Application Reference: 2025/1074

Site Address: 33 Field Head Road, Hoyland, Barnsley, S74 9AT

Introduction: Erection of a first-floor extension above existing single story side extension.

Project	Extensions & Alterations	
Client	Mr & Mrs Chris Dey	
Title	Elevations as Proposed	
Address	33 Field Head Road, Hoyland, Barnsley. S74 9AT	
Drawn By	GGG	
Scale	1:100 @ A3	Date Dec 25
Drawing No	528-05	Rev

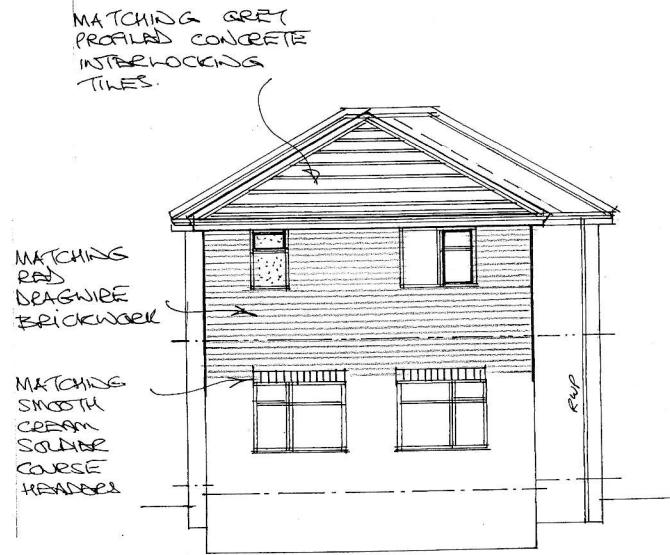
The front elevation provides two windows. Although a window with a more similar fenestration would be preferred, the use of two windows of similar height to existing on-site fenestration is considered acceptable on this occasion and prevents a completely blank elevation in the street scene.

It has been necessary to make contact with the applicant to make amendments to the front elevation of the extension to include a window at first floor level in order to avoid a blank elevation in the street scene. Amendments were received 13th January 2026.

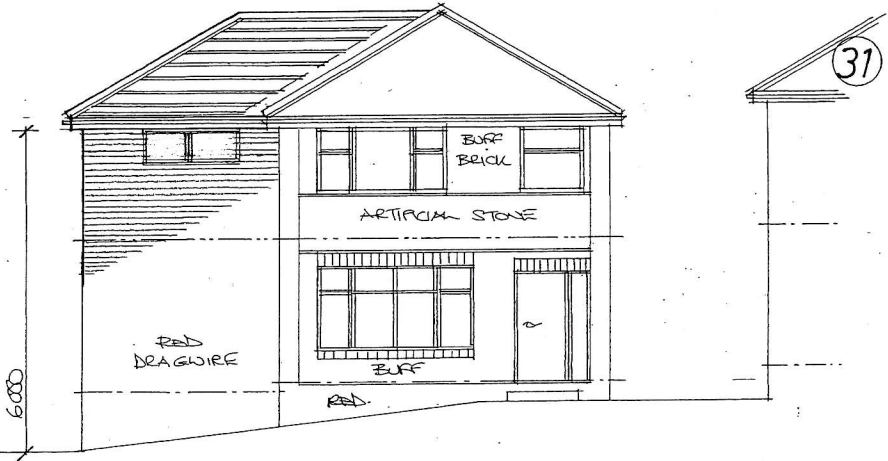
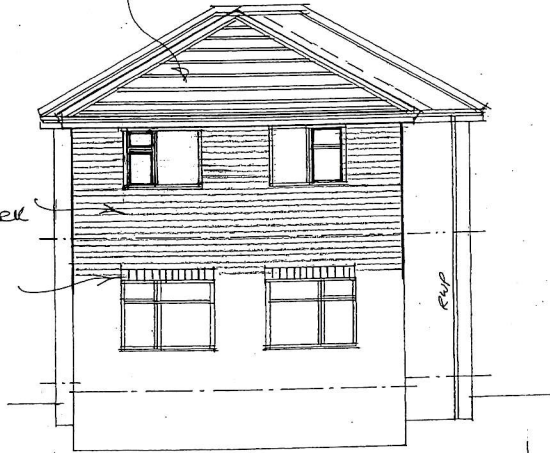
The extension provides a hipped roof form which is in keeping with the character of the dwelling and provides a significant setback from the front elevation and a setback from the rear elevation. The proposal details a significant projection to the side, however it is no greater than the existing single storey extension and remains less than two thirds the width of the original dwelling.

The amount of proposed glazing to the south elevation is not typical for side extensions, however the inclusion of glazing could be installed at a later date and is not considered to significantly detract from the visual amenity of the dwelling. The glazing also replicates the existing ground floor windows of the existing extension.

- 2) The development hereby approved shall be carried out strictly in accordance with the amended plans:

Elevations as Proposed DwgNo:528-05 Rev:A Received 06/02/2026
F.F. Layout as Proposed DwgNo:528-06 Rev:A Received 06/02/2026
Site & Locations Layout DWgNo:528-01
